Submission

Breen Resource Recovery Facility (SSD-10412)

KURNELL LANDFILL SITE
CAPTAIN COOK DRIVE, KURNELL. LOT 1122,
1123, DP 794114 & LOT 5, 6 DP 1158627
SITE PLAN

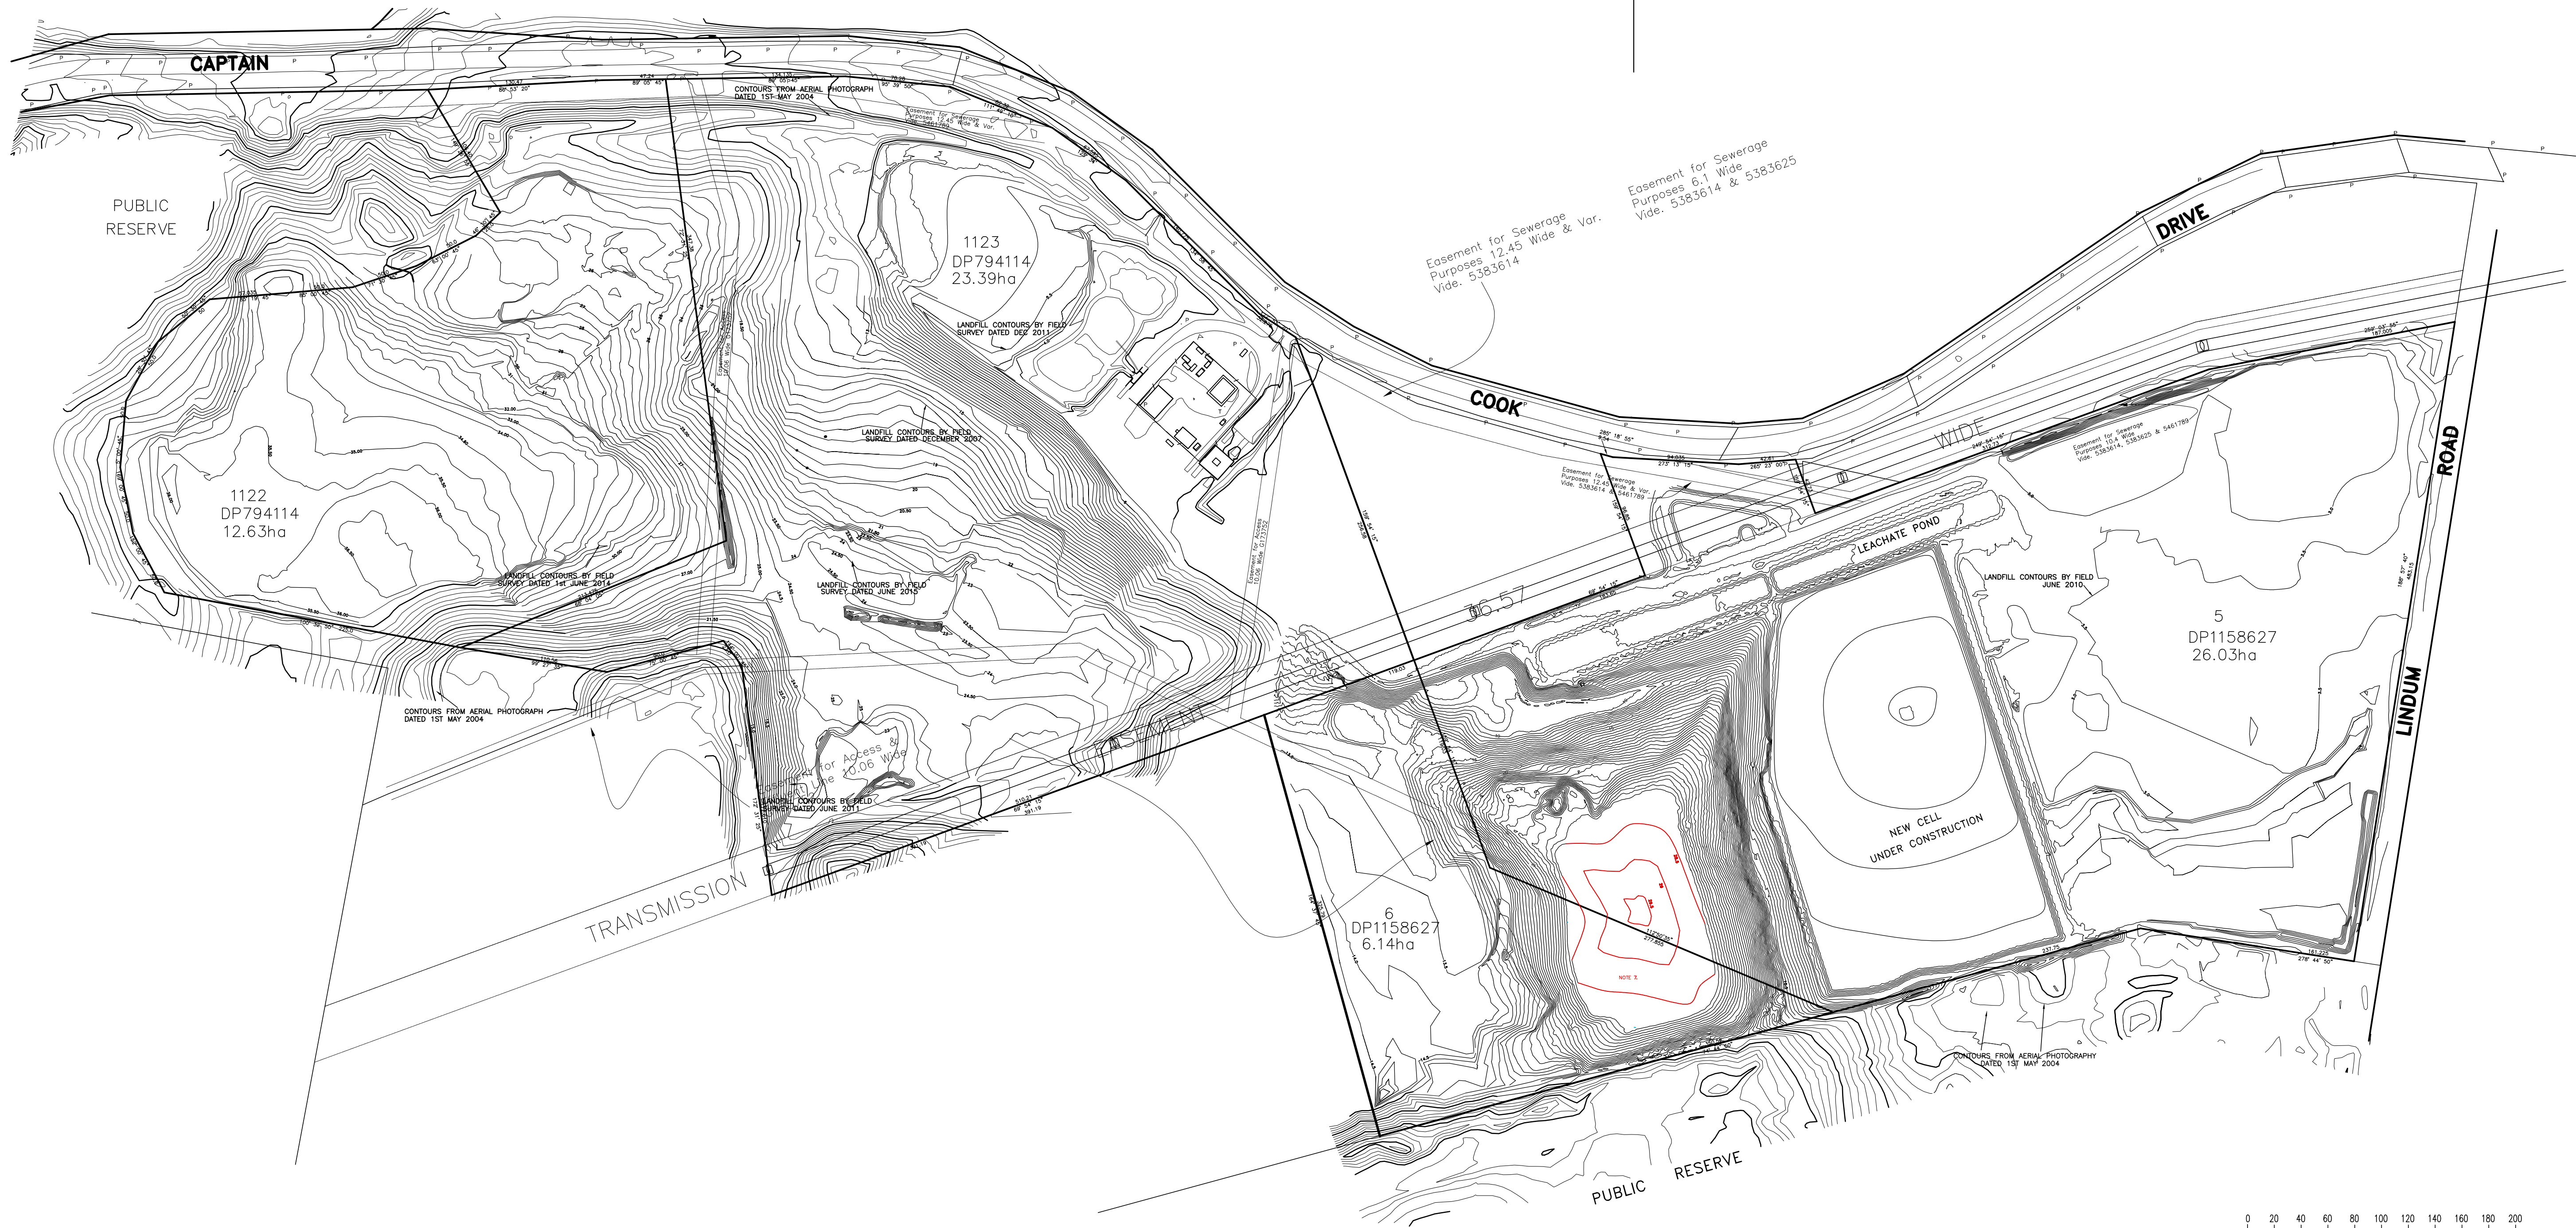
It is unclear how high the finished ground level will be in the future public reserve. A section A-A in the Landscape Plan indicates 59.5m, yet the Field Survey indicates 36.5m. It is also unclear how either of these heights compares to both:

The current and proposed (future final) height at the highest point should be clearly stated so that a proper assessment can be made of any implications for dust, noise and visual amenity.
